From: [Rich Elliott](#)
To: [Dusty Pilkington](#)
Cc: [Kirsten Sackett](#); [Joe Seemiller](#); [John Sinclair](#); [Josh Hink](#)
Subject: RE: PD-16-00001 Currier Creek (Ignore last email with duplicated subject line number from Plat : LP-17-00004 MDJ)
Date: Monday, May 22, 2017 8:23:44 AM

Subject: PD-16-00001 Currier Creek (Ignore last email with duplicated subject line number from Plat : LP-17-00004 MDJ)

SHEET NUMBER
A1.0

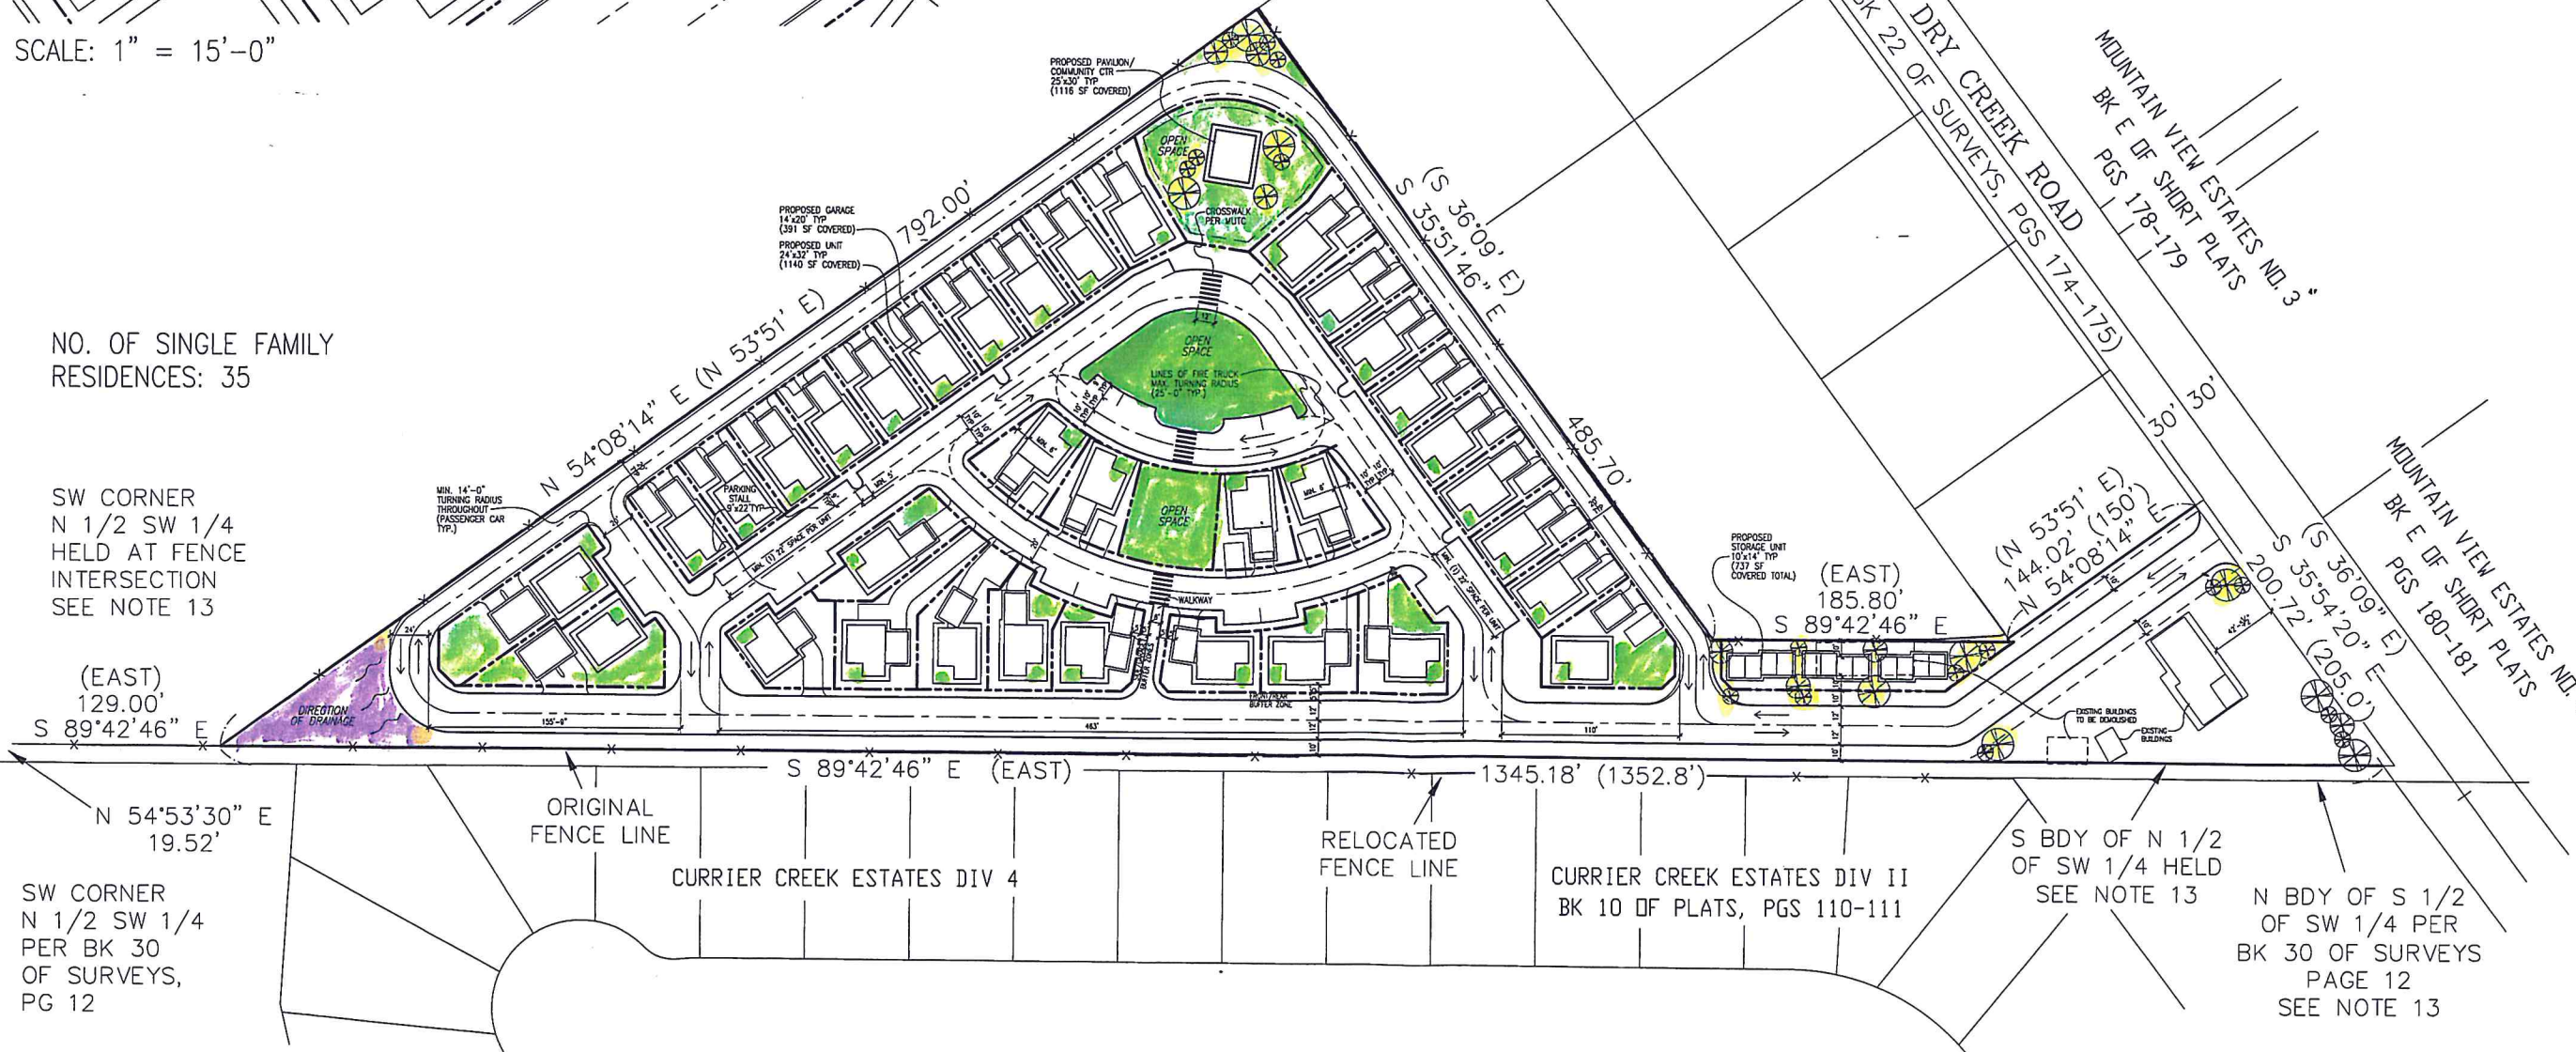
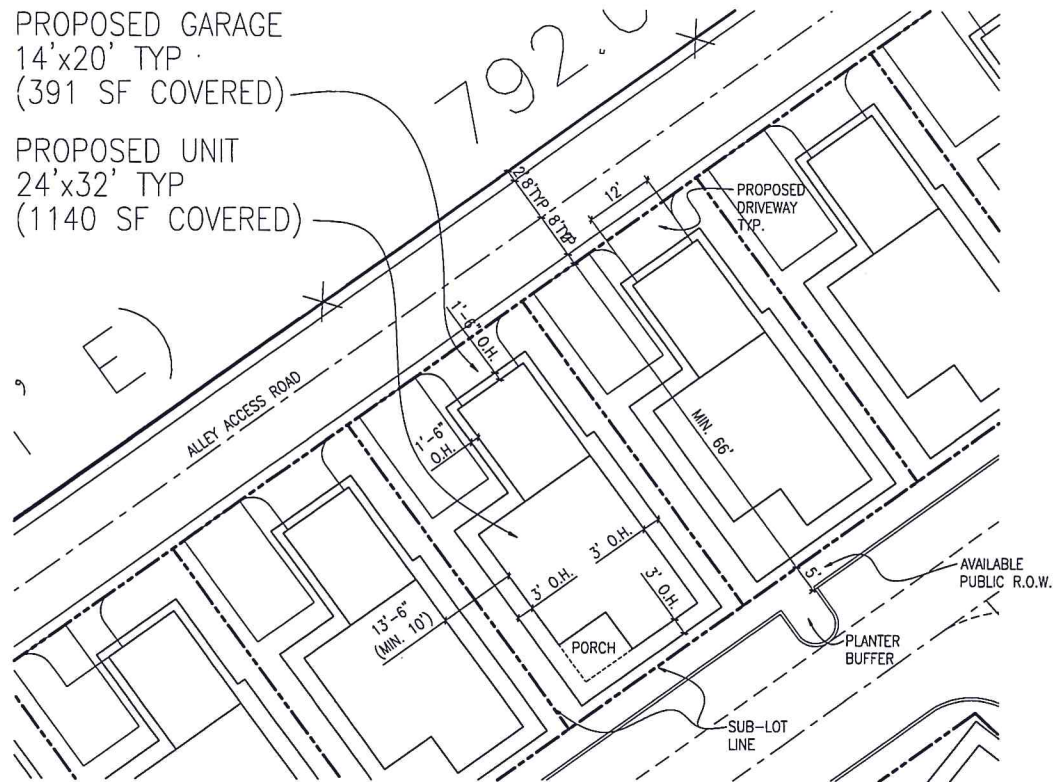
- Access roads – splitting these up seems to bypass the access road (2) requirement – KVFR desires to have 2 points of access to all developments for fire and life safety purposes.
- It is hard to tell if this proposal is for structures that are built with minimal separation? If so, KVFR would request that building materials and methods be required that mitigate structure to structure exposure risks.
- We understand that residential fire sprinkler systems will likely not be required but we request they be considered.
